Appendix L - The Sandstone Precinct– SSD 6751 MOD 2 and SSD 7484

Response to Government Agency Submissions

Proposed Shadows March 21, 3 PM

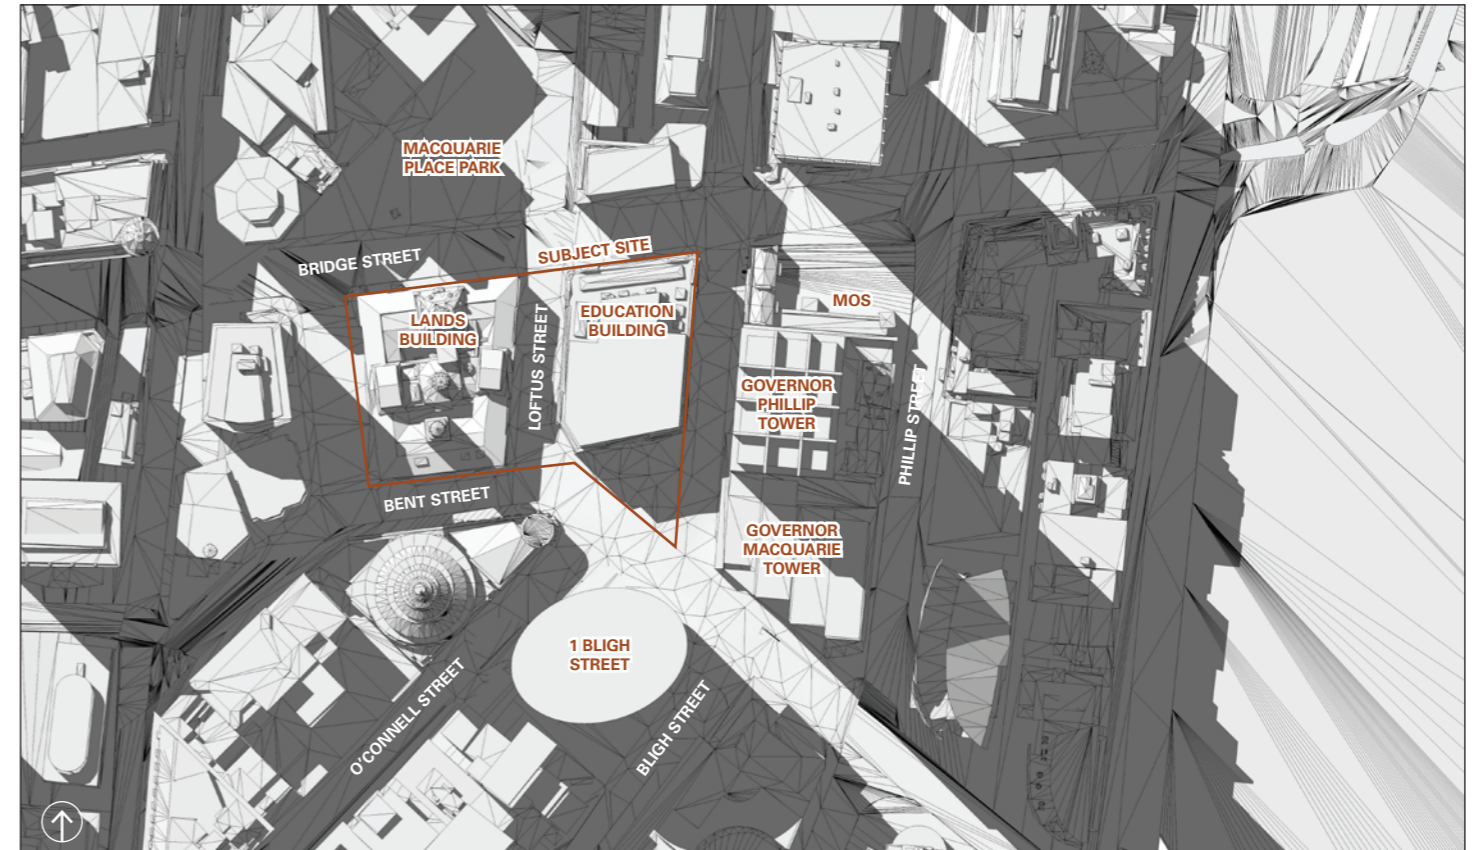
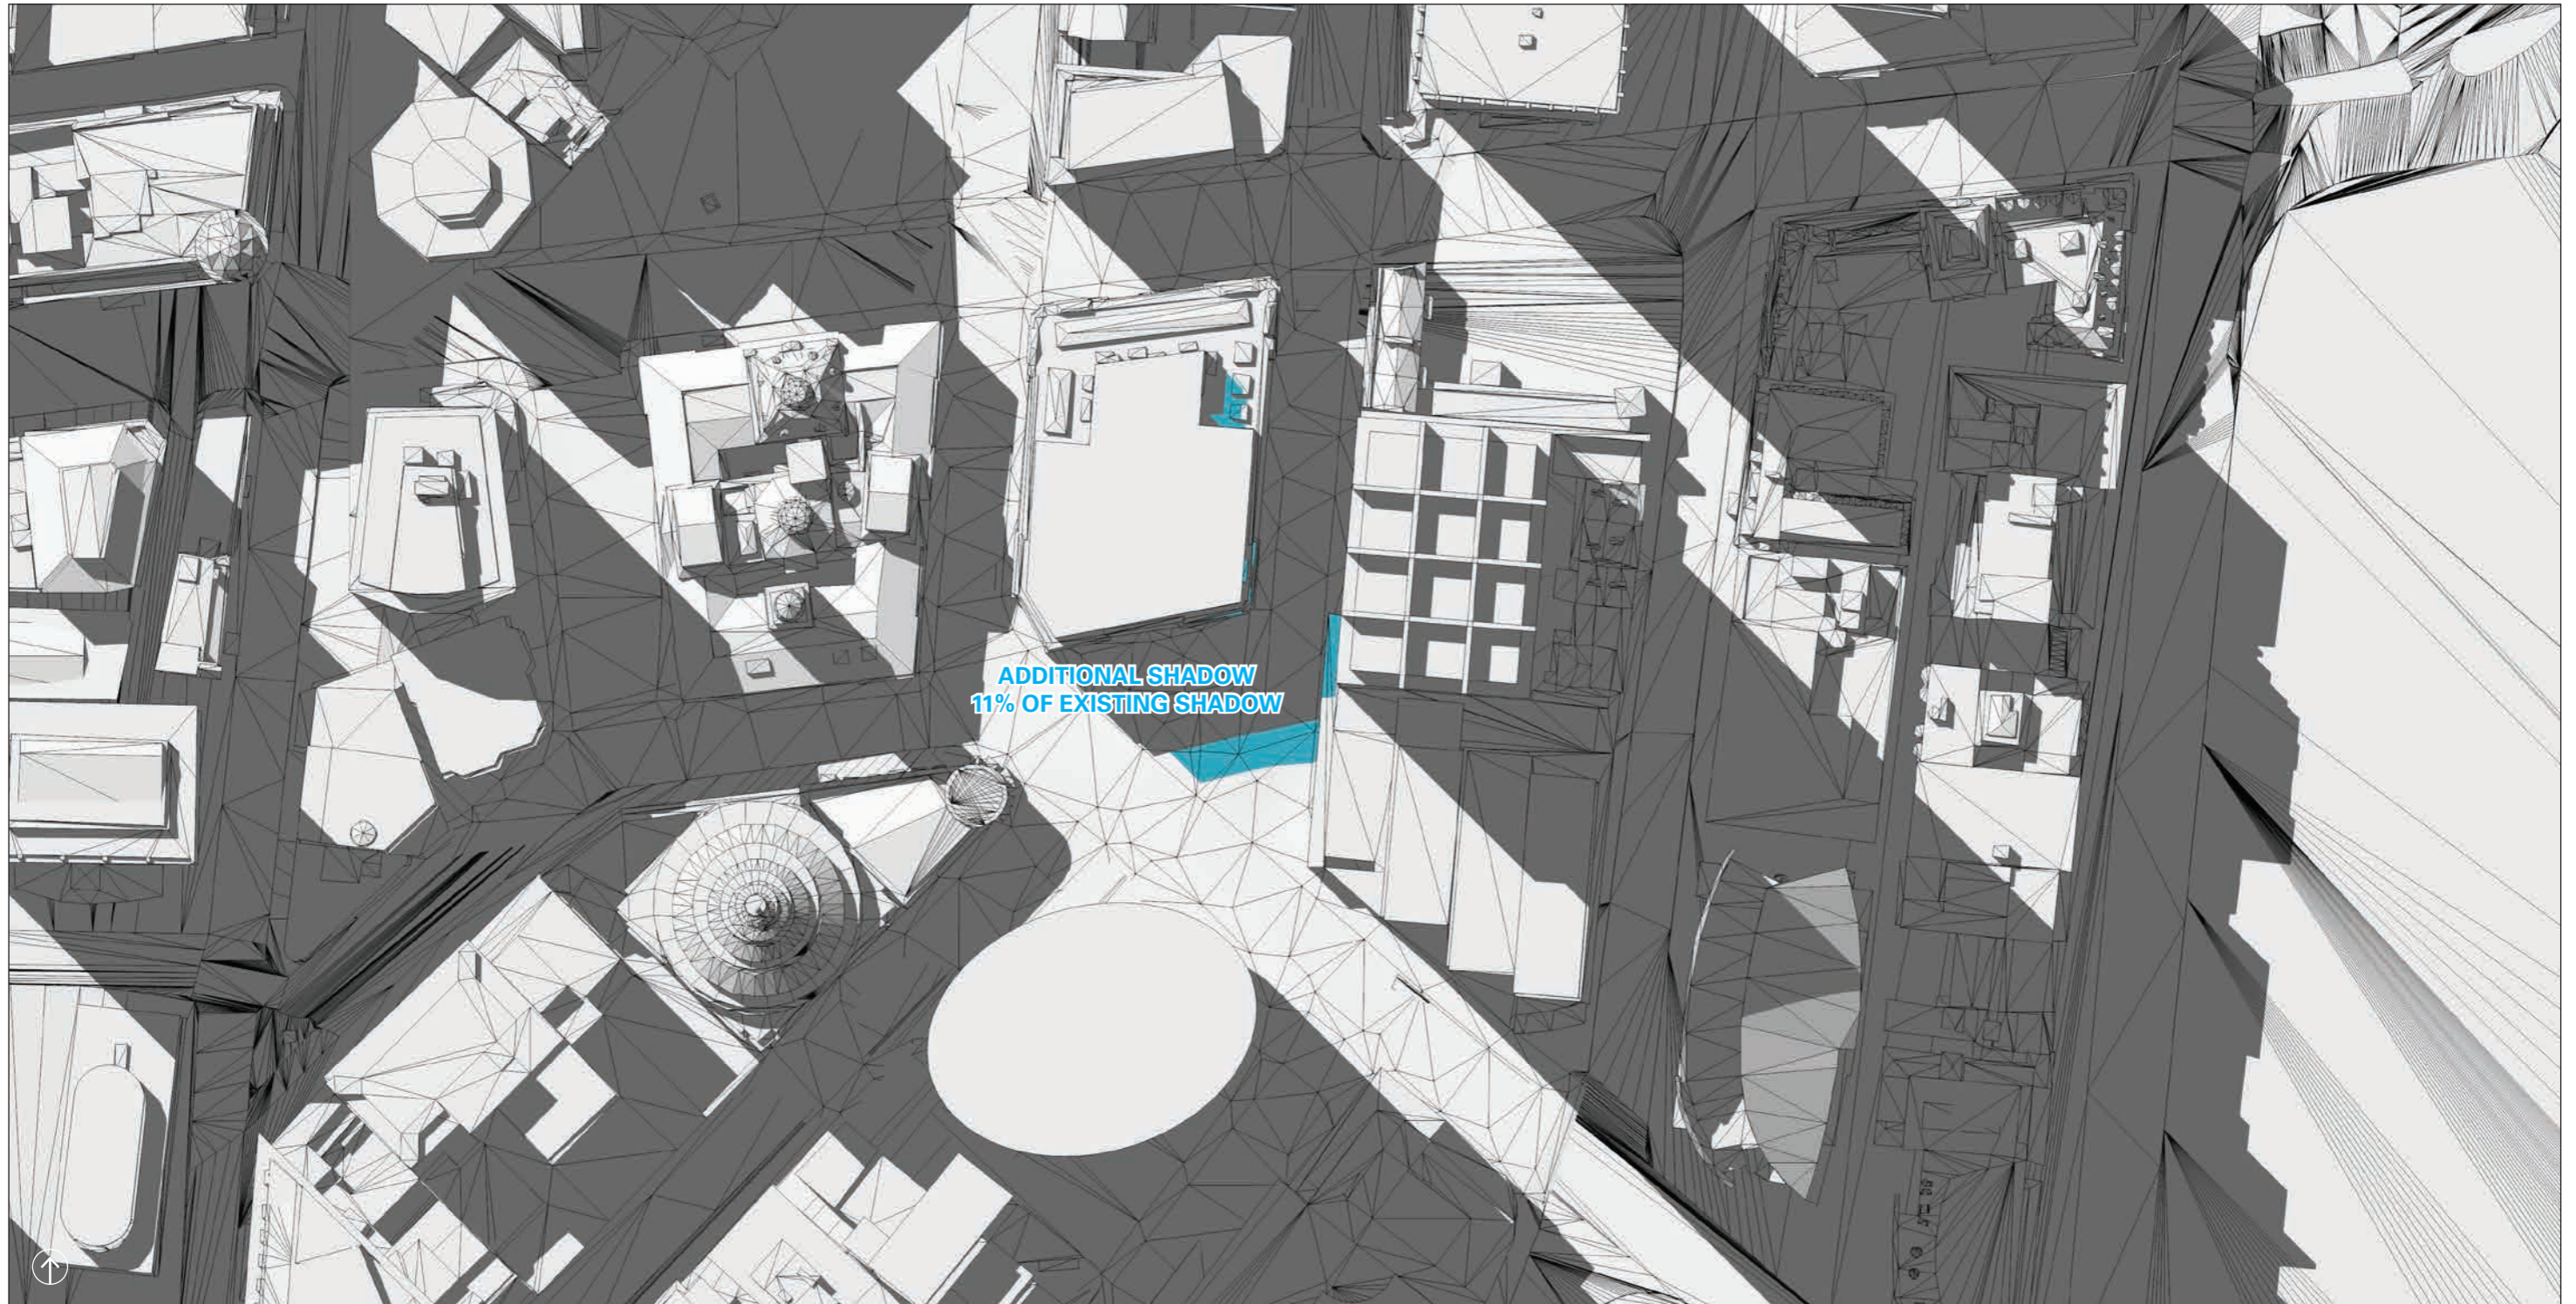
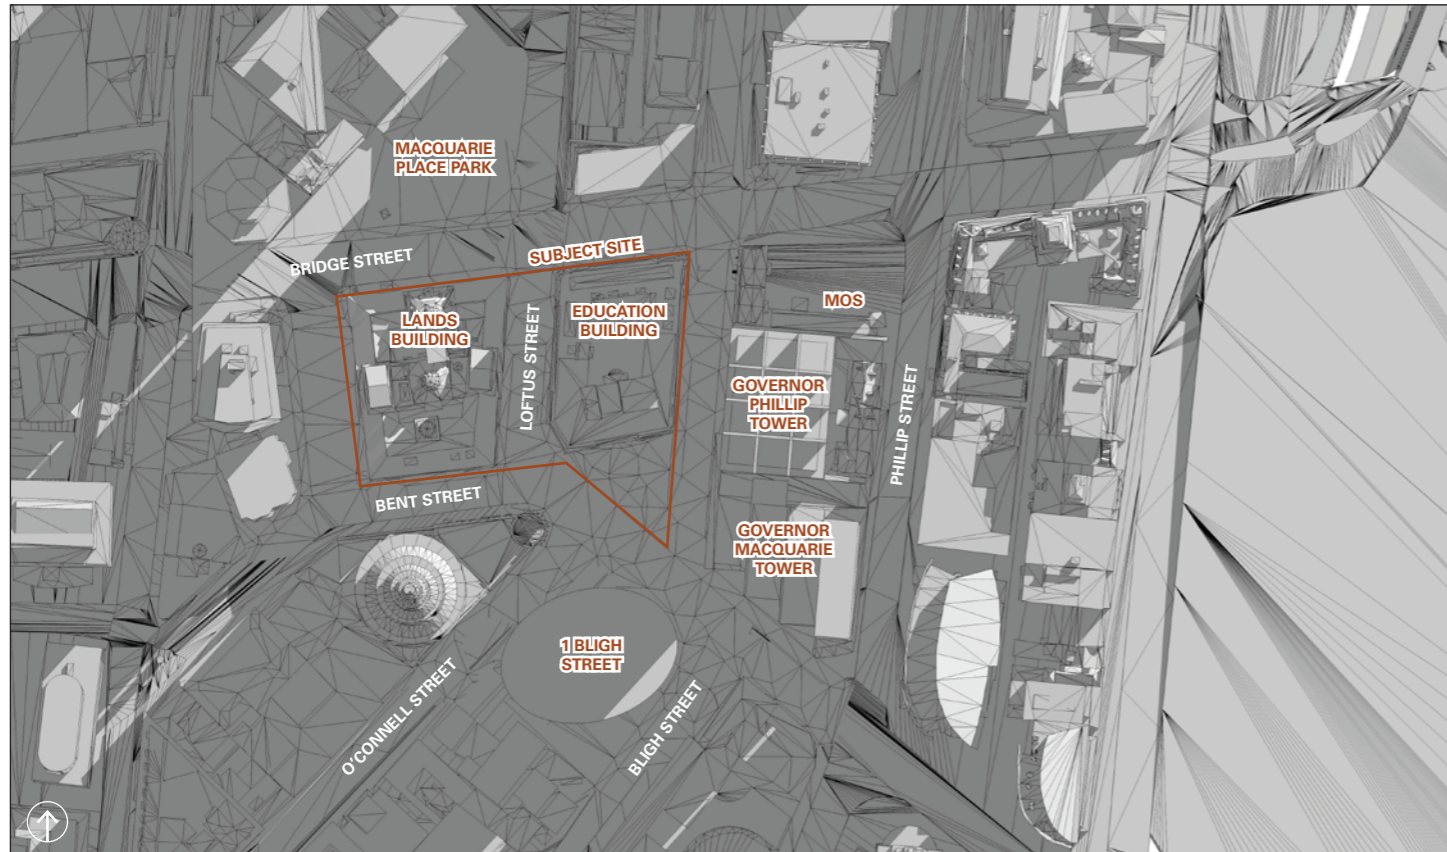
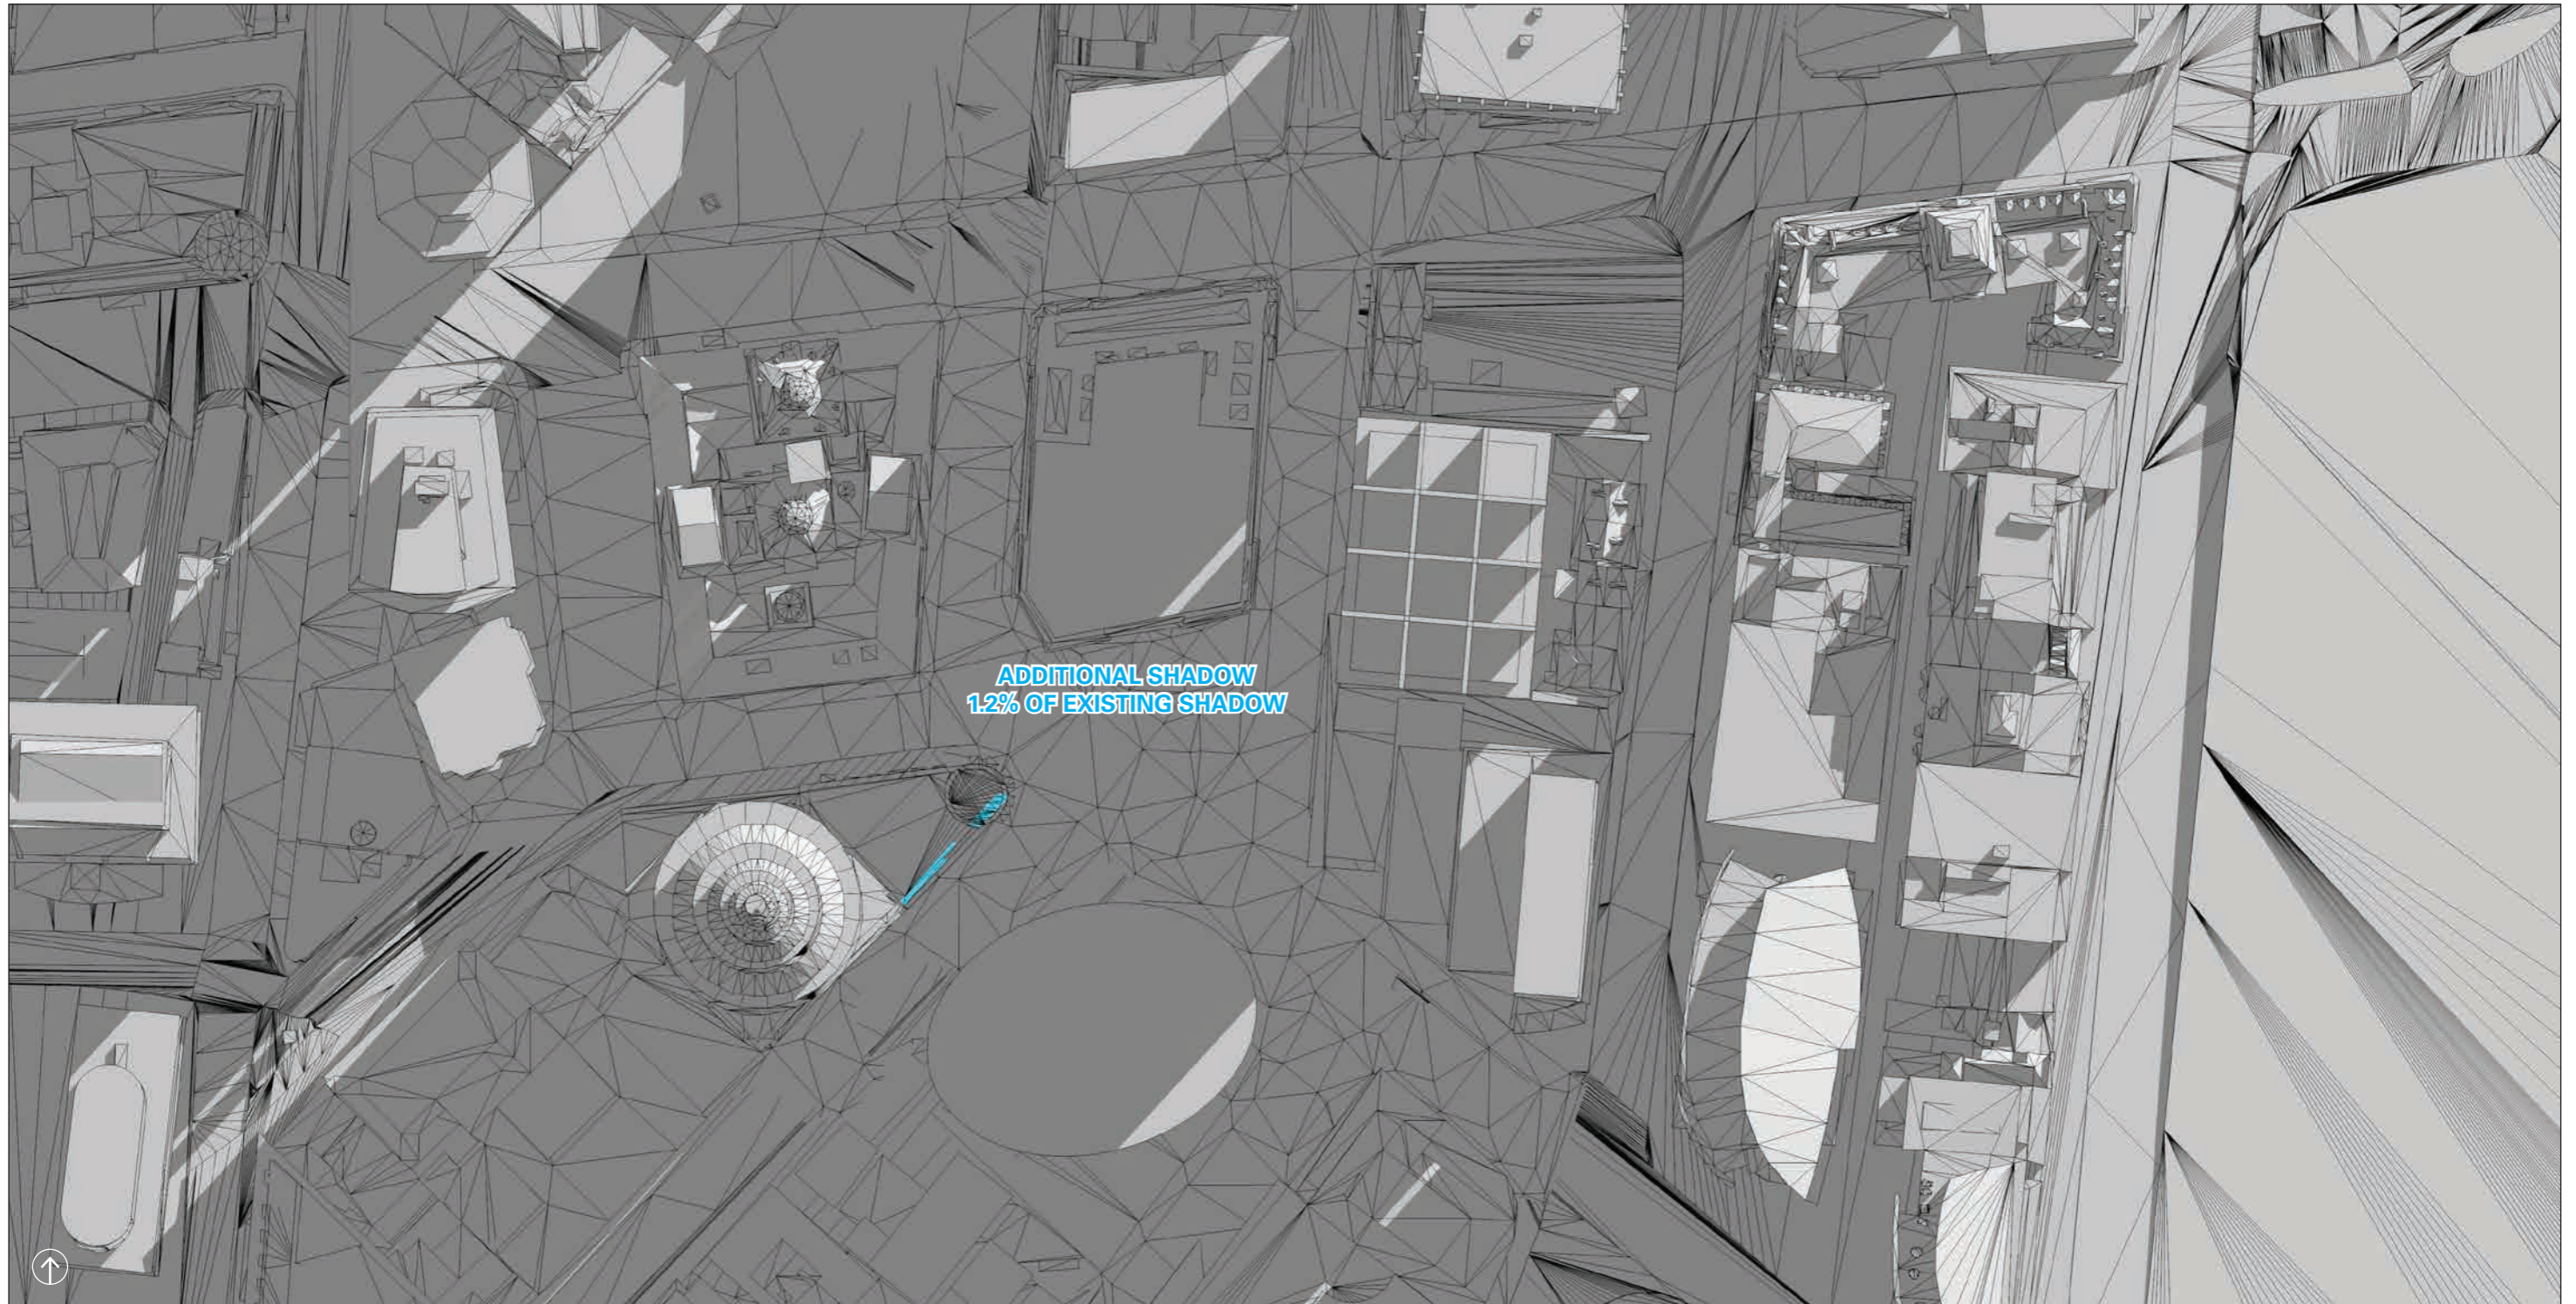
<ul style="list-style-type: none"> Any increase to the roof level of the Education Building would impact upon solar access of Farrer Place and is not supported. 	Additional shadow diagrams have been prepared that demonstrate the shadowing of Farrer Place under Stage 2 is less than that of the approved Stage 1 envelope (Refer to Appendix J).
<ul style="list-style-type: none"> Both the Lands and Education buildings are of State Heritage significance and should be treated accordingly. Lessening the impact on one building only to justify increasing heritage impact on another is not an acceptable heritage outcome. 	Noted. The use of the proposed buildings and roof envelope of the Education Building was approved at Stage 1.
<ul style="list-style-type: none"> The Trust voices its concerns about the potential decrease in public space in Farrer Place through the construction of a new vehicular drop-off leading from Bent Street. 	The reduction of public space by the new drop off will be offset by the increased public space created at the intersection of Loftus Street and Bent Street. The nett result is that Farrer Place will remain the same size.
